**Application Reference:** 6/2022/2218/COND

**Proposed development at:** 35-37 Howardsgate Welwyn Garden City AL8 6AP

**Proposal:** Submission of details pursuant of condition 1 (noise), 2 (noise control) and 3 (ventilation) on planning permission 6/2022/0733/FULL

ROOF LAYOUT

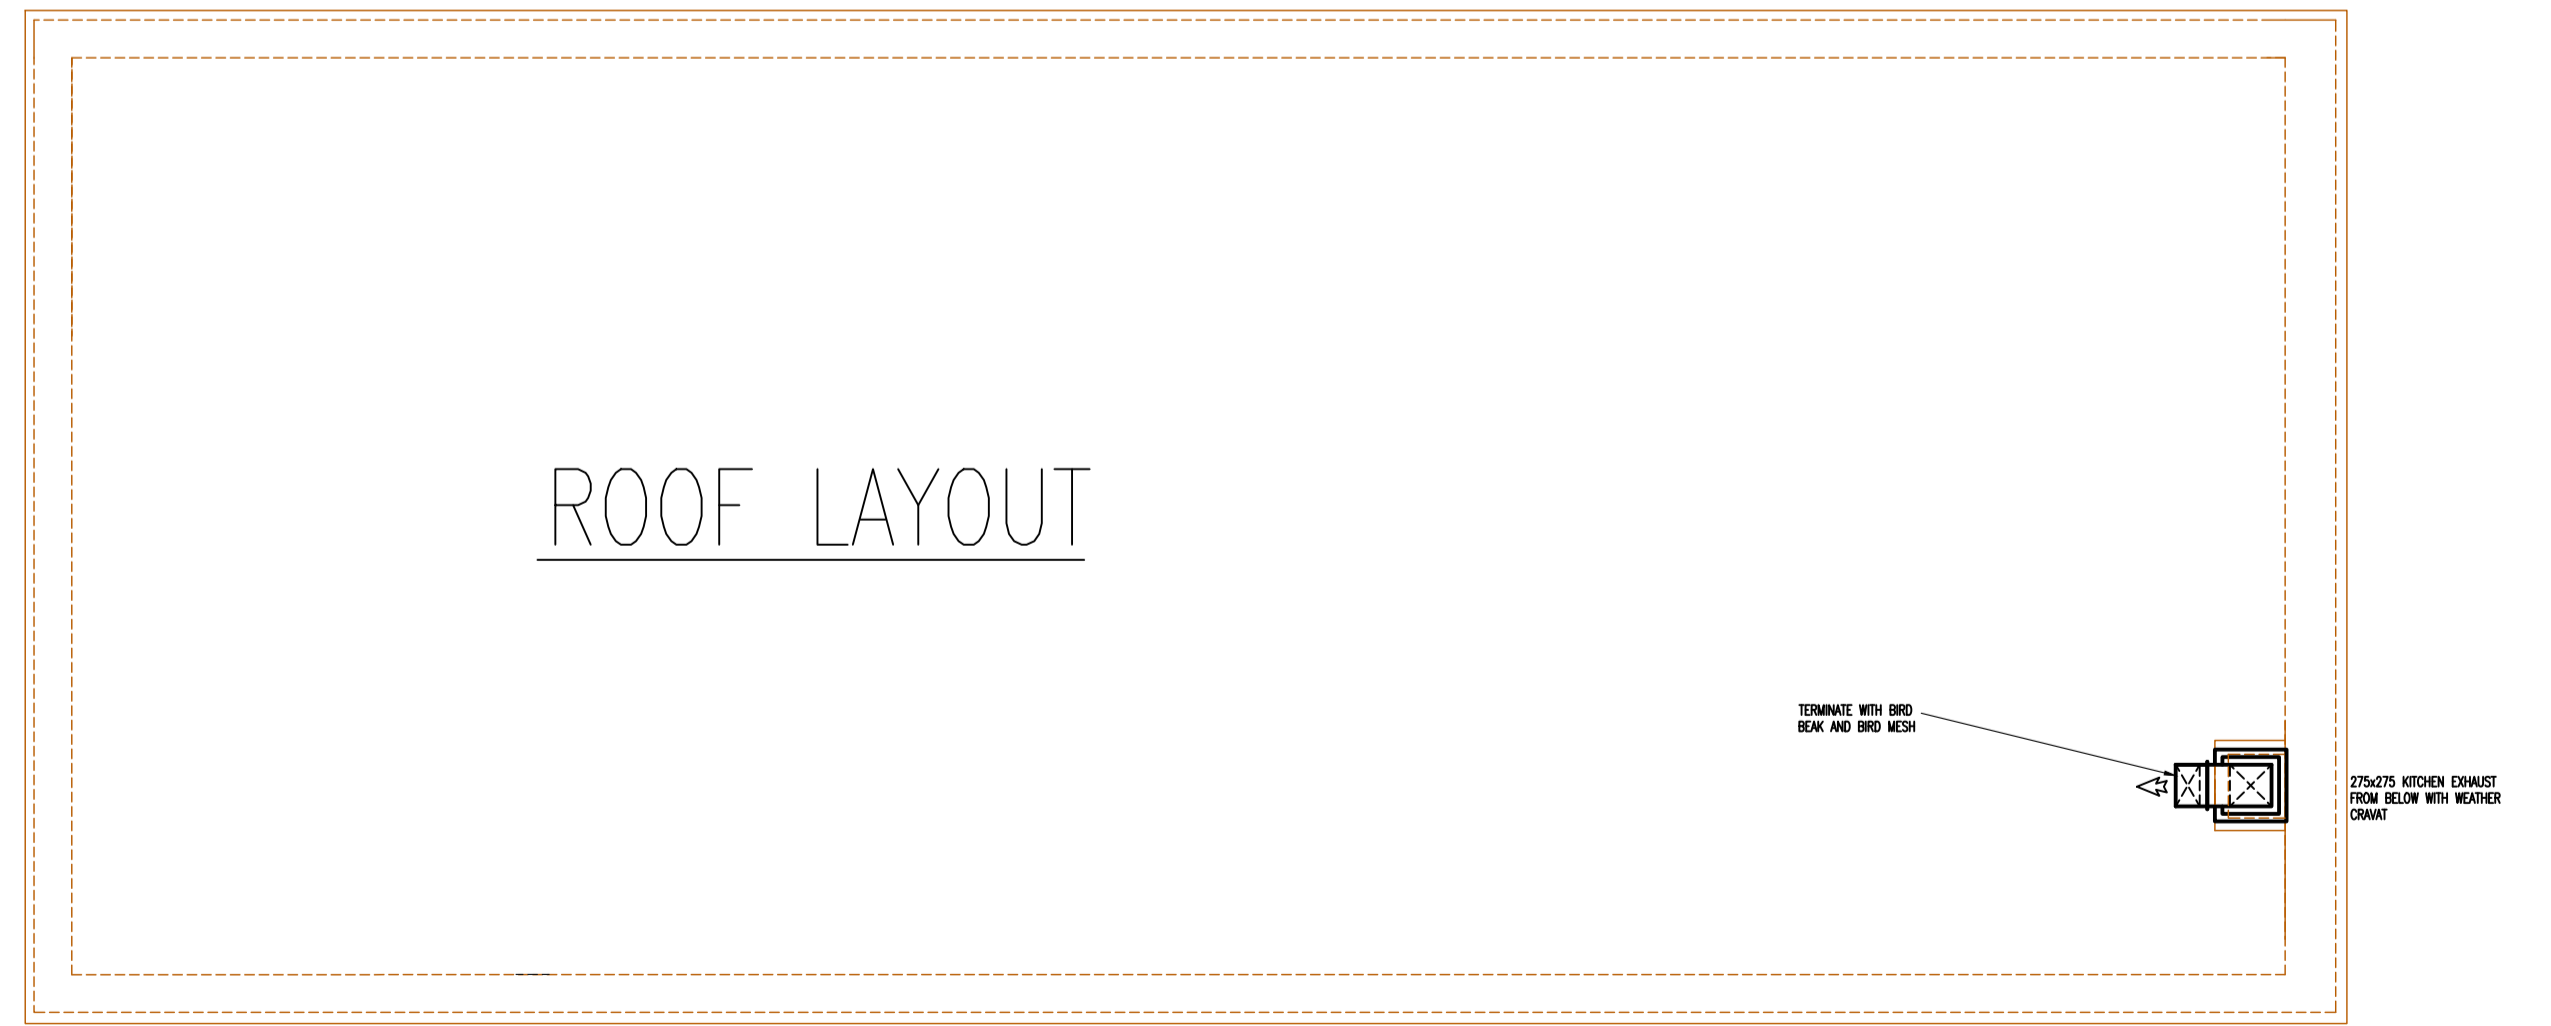
*“1.5 Compliance with Planning Condition 1 is predicted to be achieved subject to the installation of a 2m high imperforate acoustic barrier (minimum surface density of 10kg/m<sup>2</sup>) to the east of the three AC condenser units at roof level.”*

The acoustic barrier is also shown as part of the appendix to the report.

No such barrier has been granted planning permission as part of application ref: 6/2022/0733/FULL. You will need to submit a planning application for planning permission for this type of acoustic barrier, alongside a noise survey.

Having regard to the above, insufficient information has been submitted to discharge condition 1.
